RFI

RFI #: 28
Date: 1/5/2012
Job: EB-02 Keller Springs Lofts
Phone: 877-777-5115

Subject: Pit detail

Drawing: SG2.01 & 5/SG3.02
Cost Impact: None

SG3.02

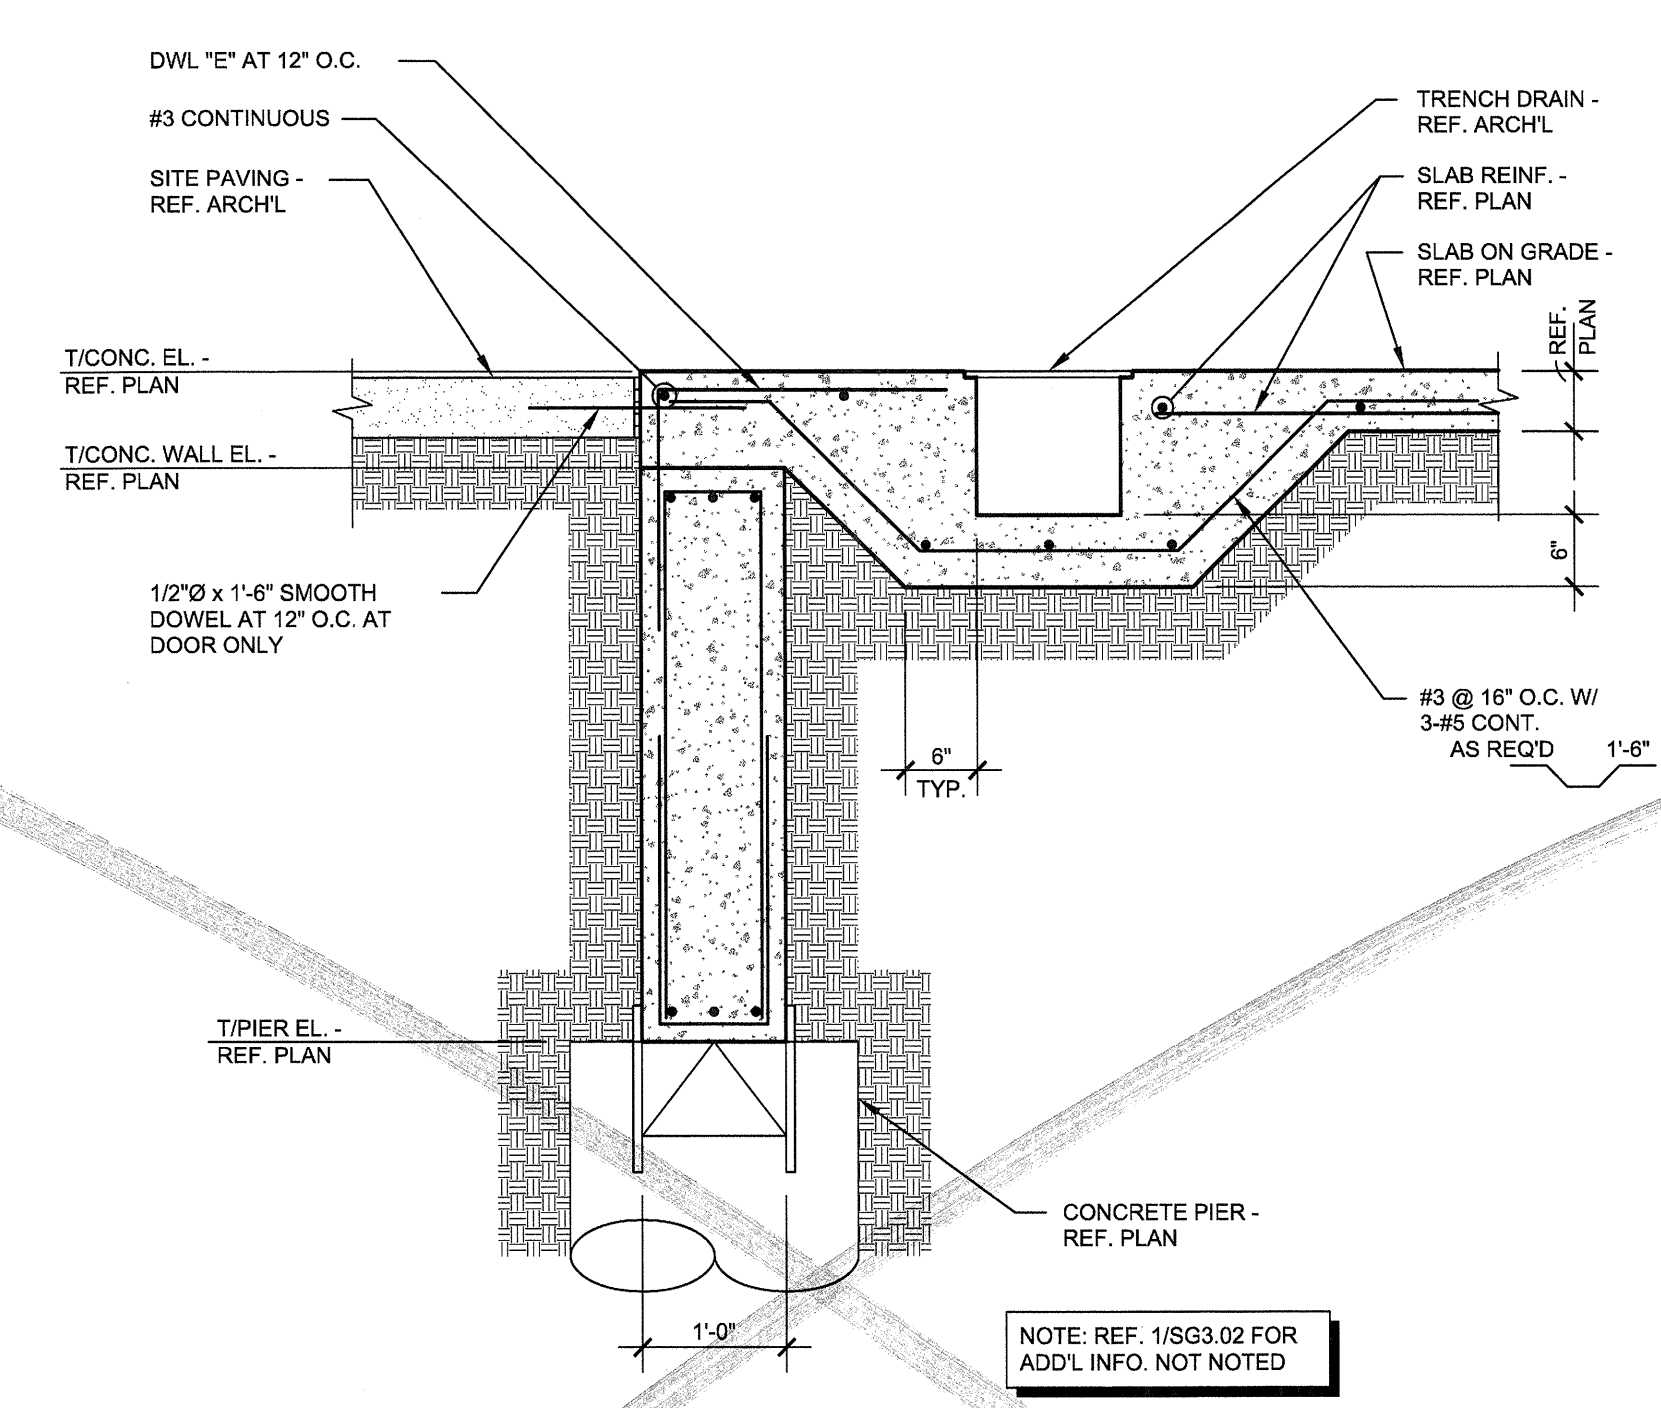
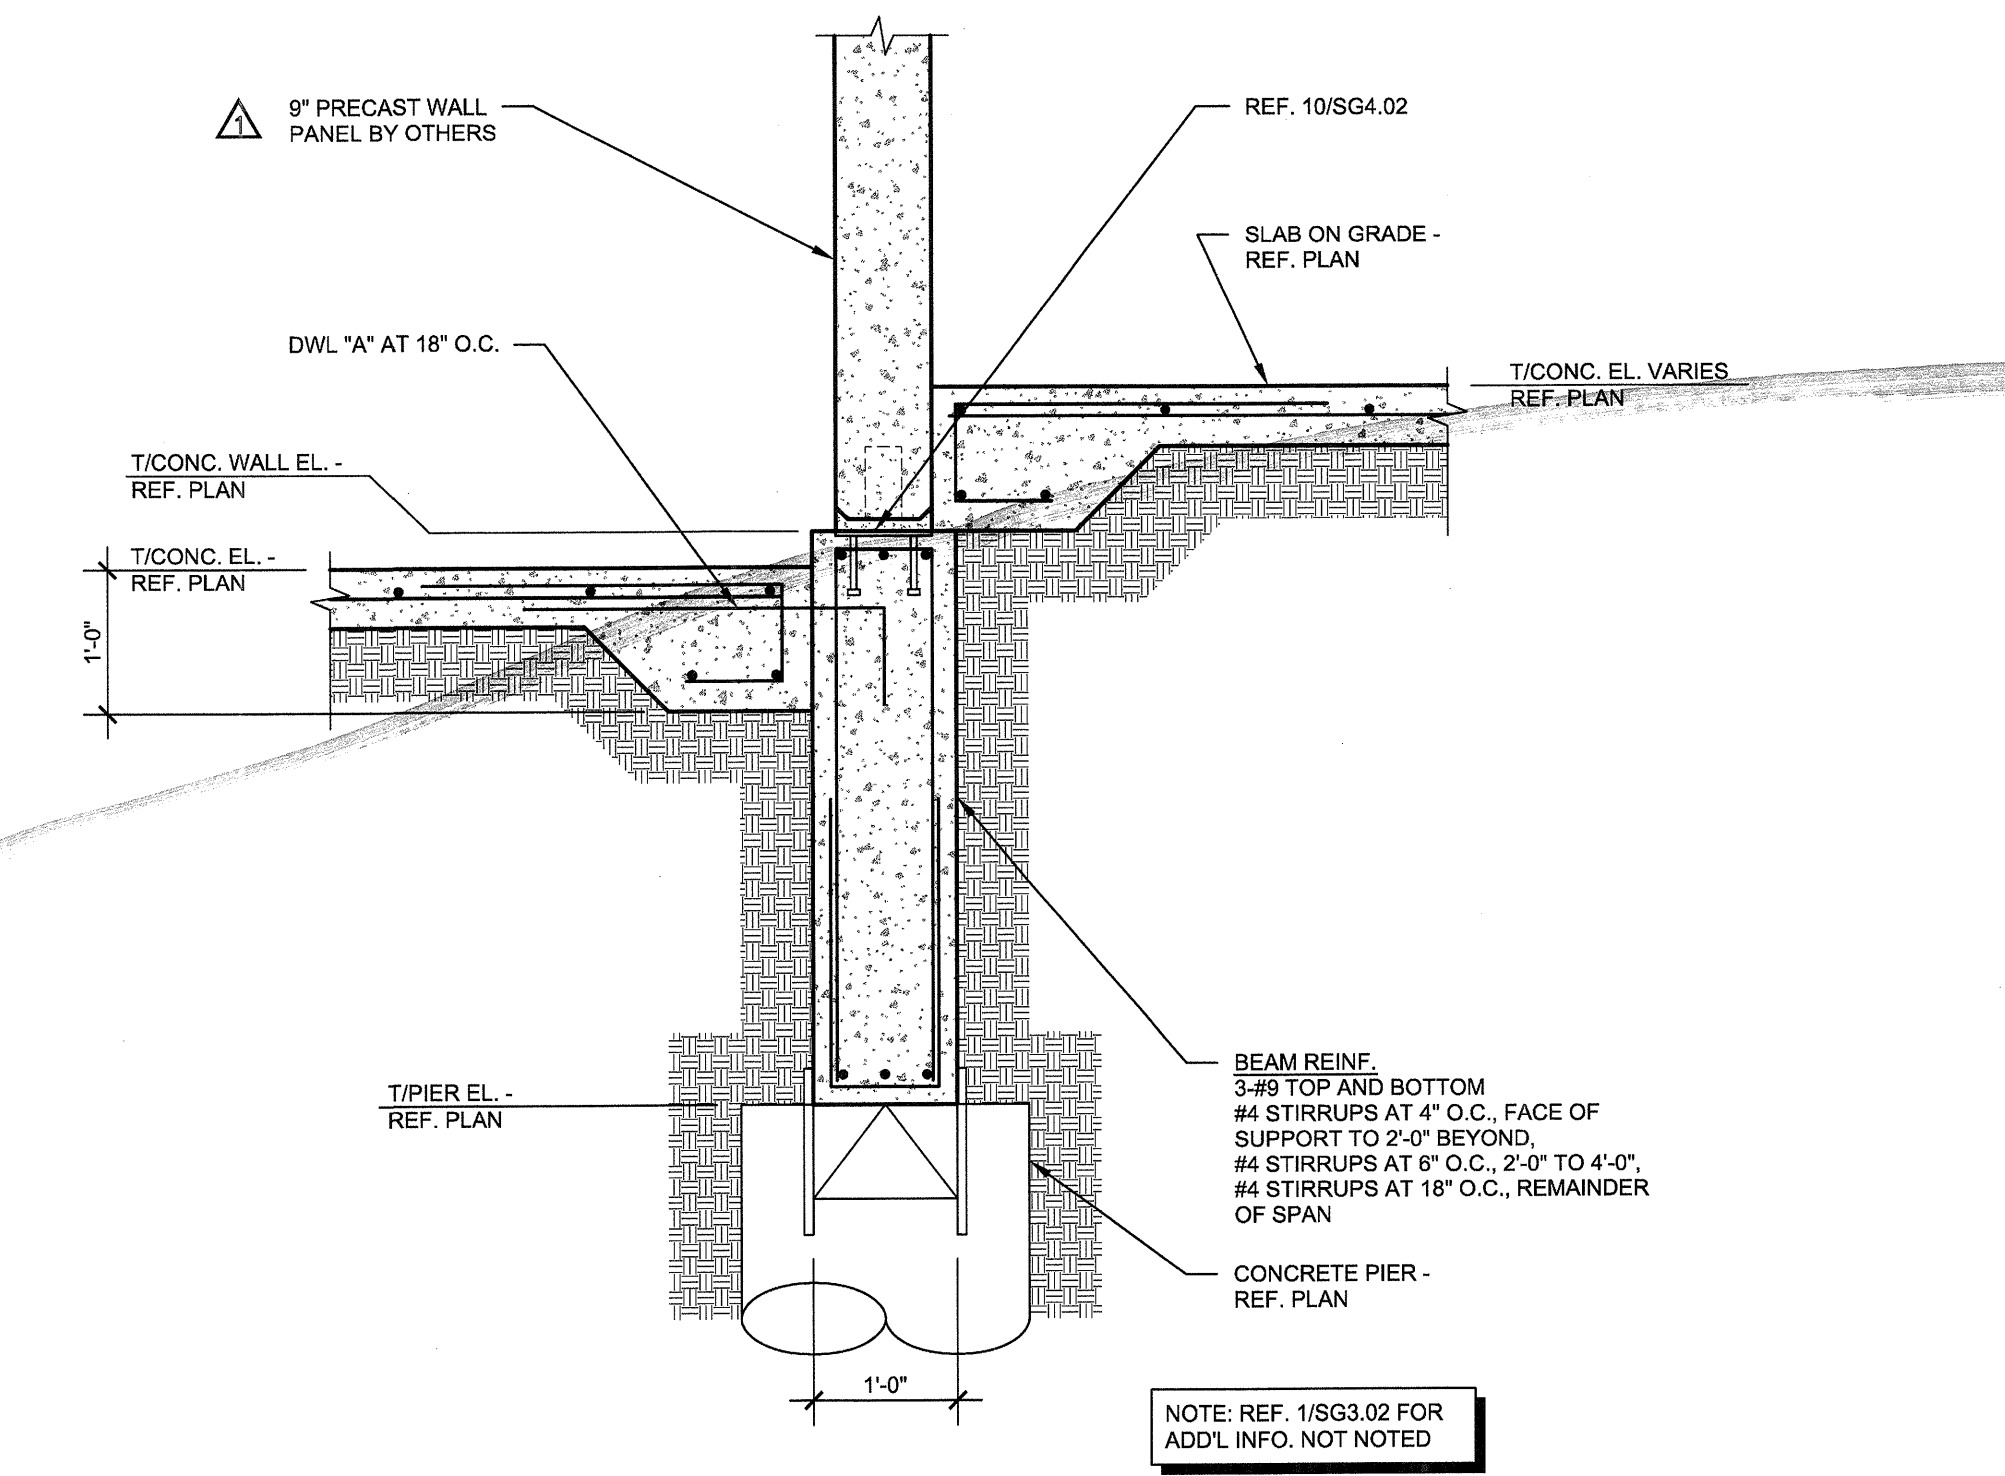
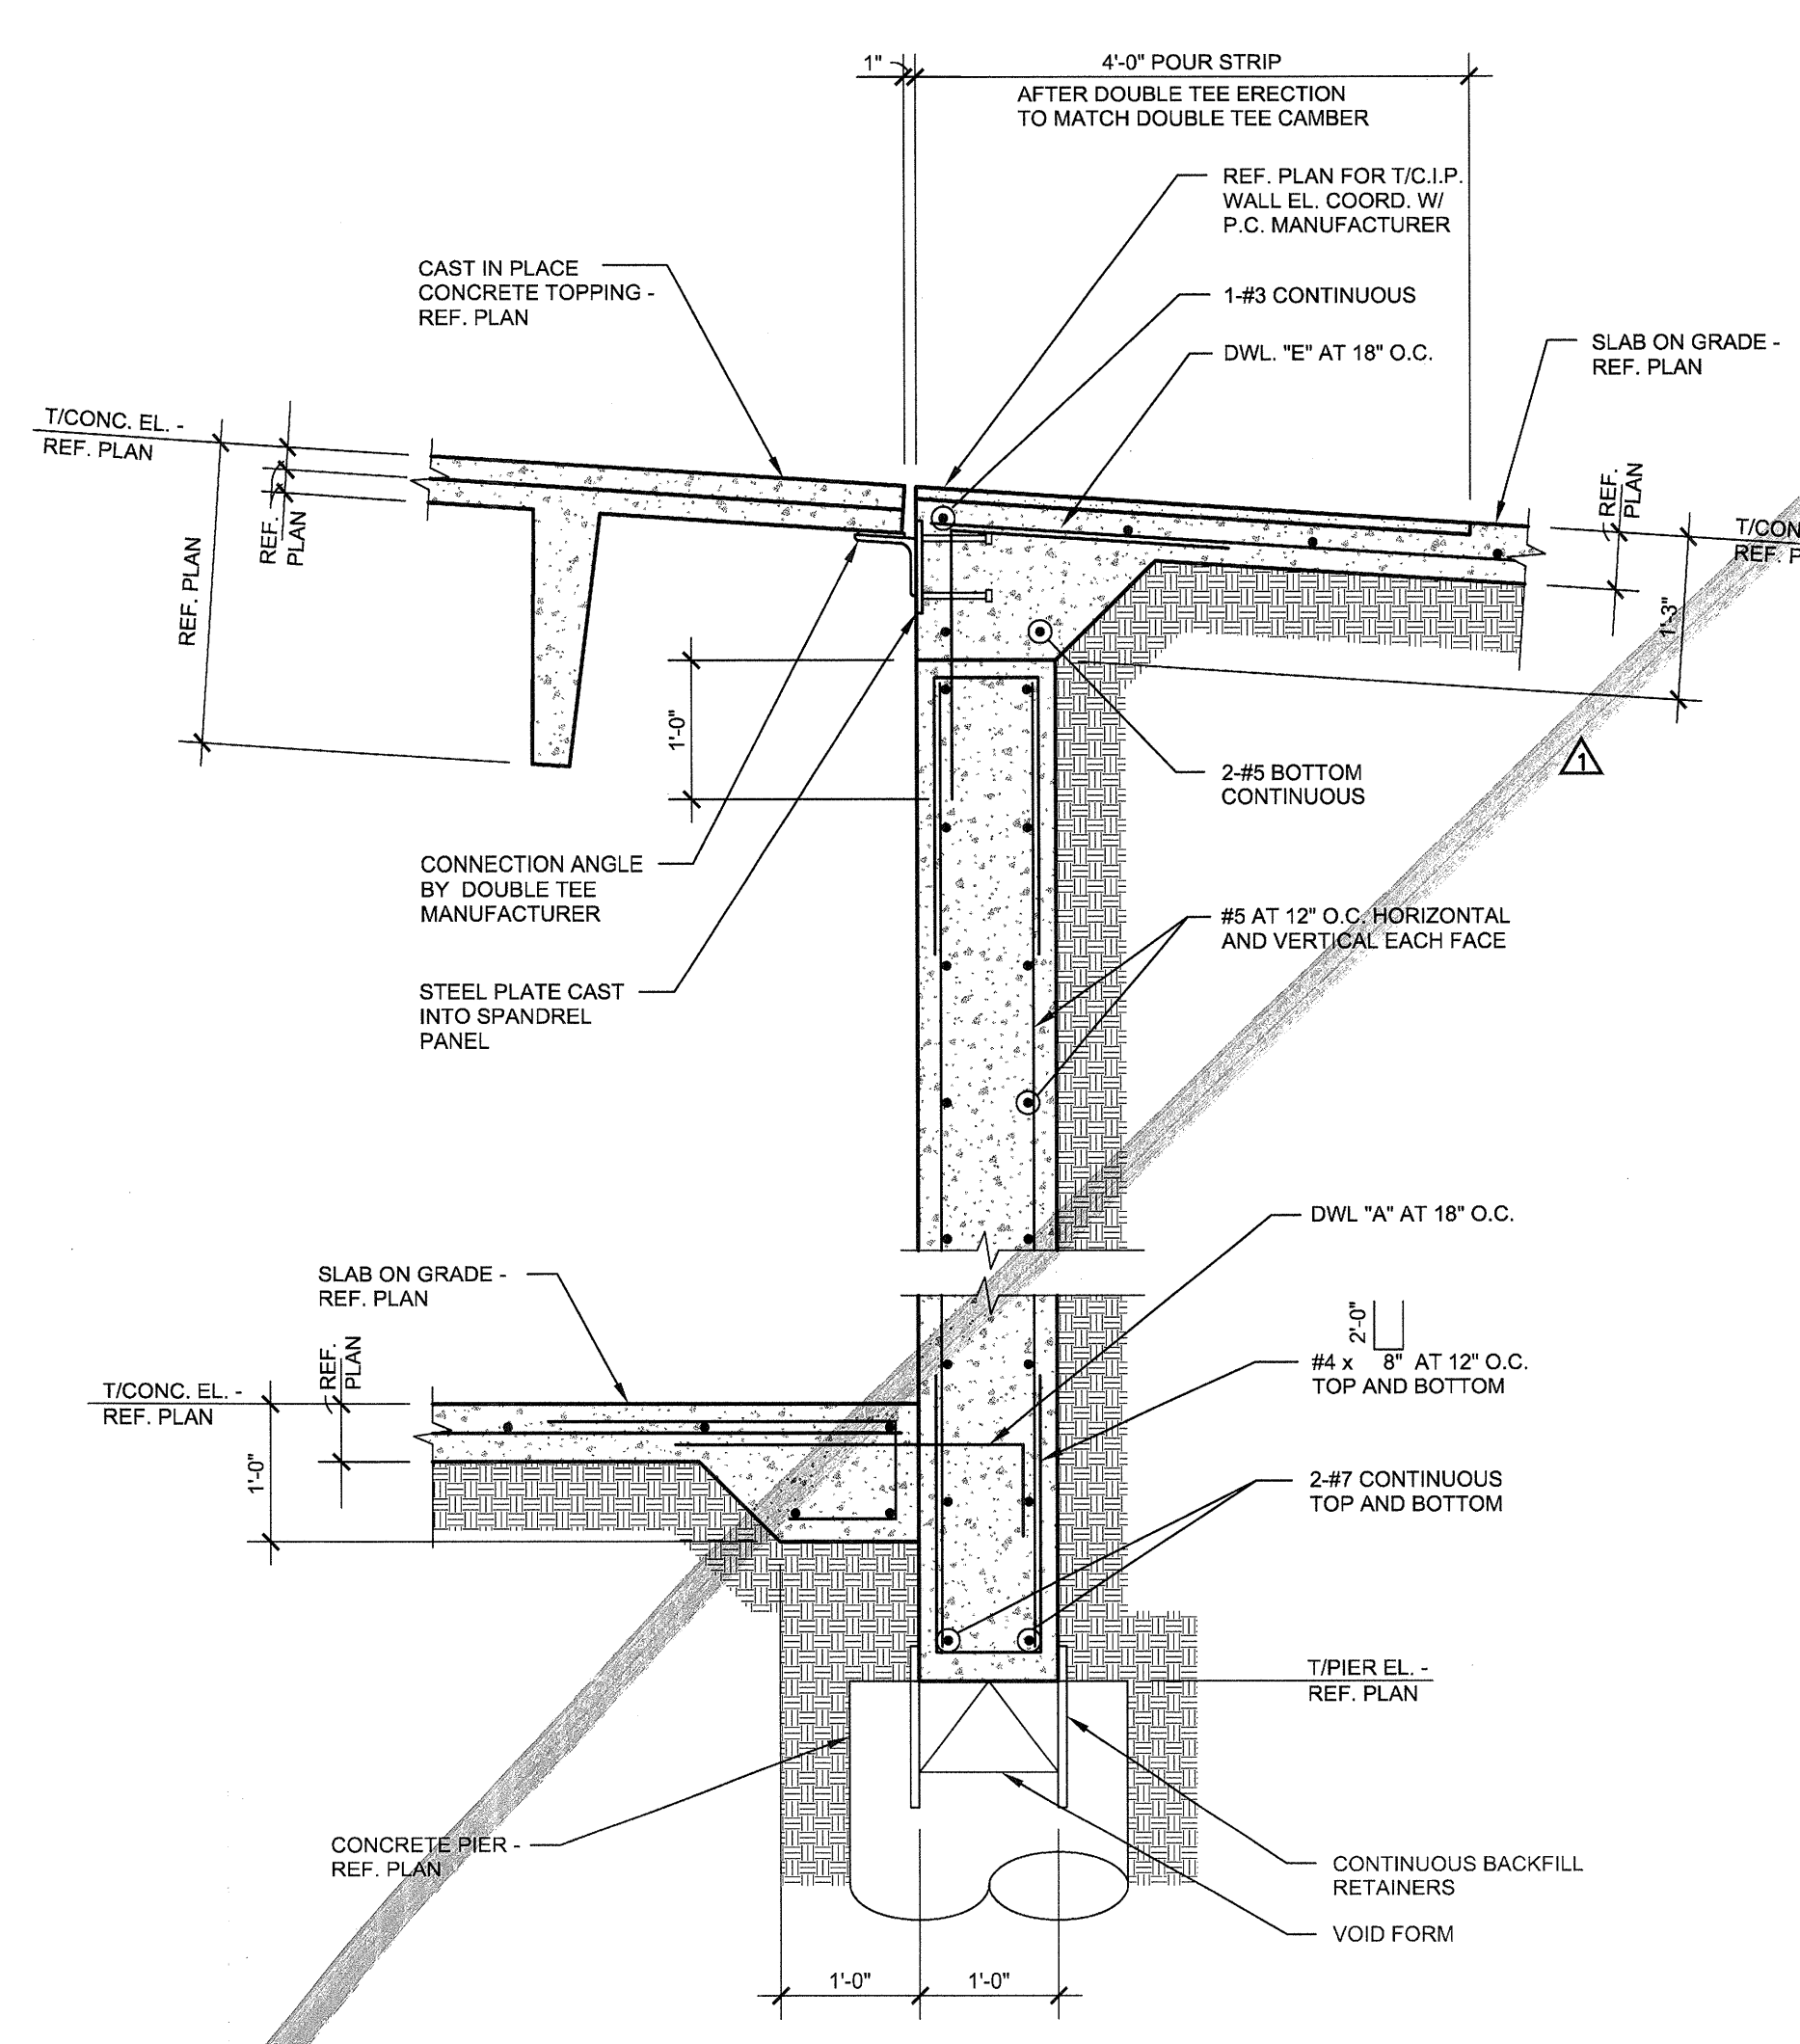
Request: Date Required: 1/12/2012
On sheet Sg2.01 we have a cut through 5/SG3.02 show a pit detail at ventilation shaft. What pit and Why? Please advise

Please refer to revised drawings issued on January 25, 2012. If you have questions or require additional information regarding this matter, please do not hesitate to contact us.
